**City of Portland, Maine – Building or Use Permit Application** 389 Congress Street, 04101, Tel: (207) 874-8703, FAX: 874-8716

**BUILDING PERMIT REPORT**

REASON FOR PERMIT: Repair existing deck

Re: Review of Exterior Wood Deck Improvements  
94 Primrose Lane, Portland, Maine  
CME Project No. 99-060

framing detail of large deck

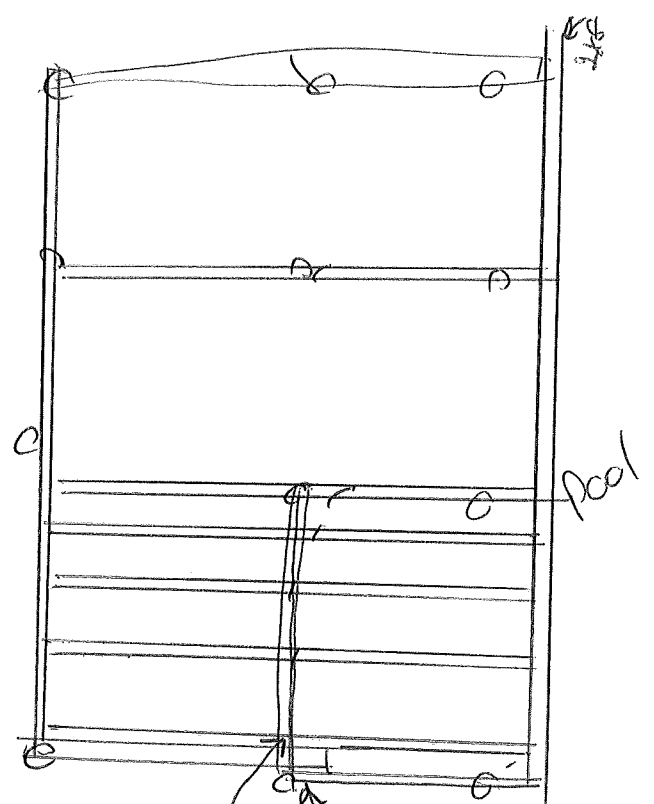
7. *Previous Recommendation:* Perimeter beams supporting decking joists should be increased in size to either 4x12 beams or additional posts and sonotubes should be installed so that the beam is supported at 4 feet on center. *Told to increase size.*

*Current Condition:* A single 2x8 was anchored to the face of the existing 2x8 beam, and one additional post was installed. This is still structurally inadequate.

8. *Previous Recommendation:* The perimeter beam should be bearing directly on timber posts underneath instead of being face-nailed to the sides of the post. *Told about this.*

*Current Condition:* The existing beam appears to have adequate bearing underneath; however, the new 2x8 applied does not.

- \*35. Maximum span of 2x8" at 16" on center is 12'-
- \*36. Where protection of wood members is required because of exposure to soil or weather protection shall be provided by using naturally durable or preservation-treated wood.
